Planning Consultation Request

Observations By:	KC, Lead Local Flood Authority
Application No.	2023/93342
Proposed Development:	Outline application for demolition of existing dwelling and garage and erection of two detached dwellings with attached garages
Location:	Moss View, Burnlee Road, Holmfirth, HD9 2LE
OS Map Reference	SE 413276.9016 407804.4183
Applicant/Agent:	Northern Design Partnership
Class:	Minor Developments

Consultation Response from KC, Lead Local Flood Authority
2023/93342 Moss View, Burnlee Road, Holmfirth, HD9 2LE
Outline application for demolition of existing dwelling and garage and erection of two detached dwellings with attached garages
Date Responded: 5th June 2024 Responding Officer: Paul Farndale Responding Ref:

SITE PLAN (1:200)

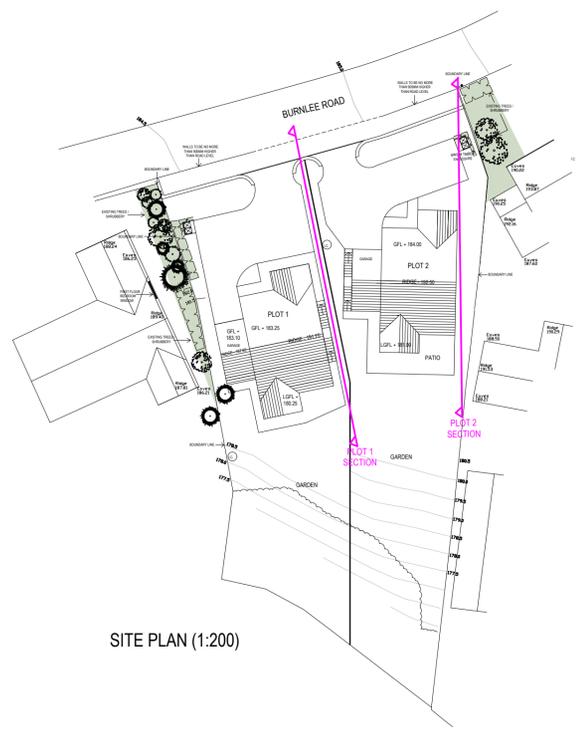
The watercourse has been located and will run along a shallow line, allowing for hand dig repairs when/where necessary. This represents a diversion to the original line.

We can SUPPORT this application.
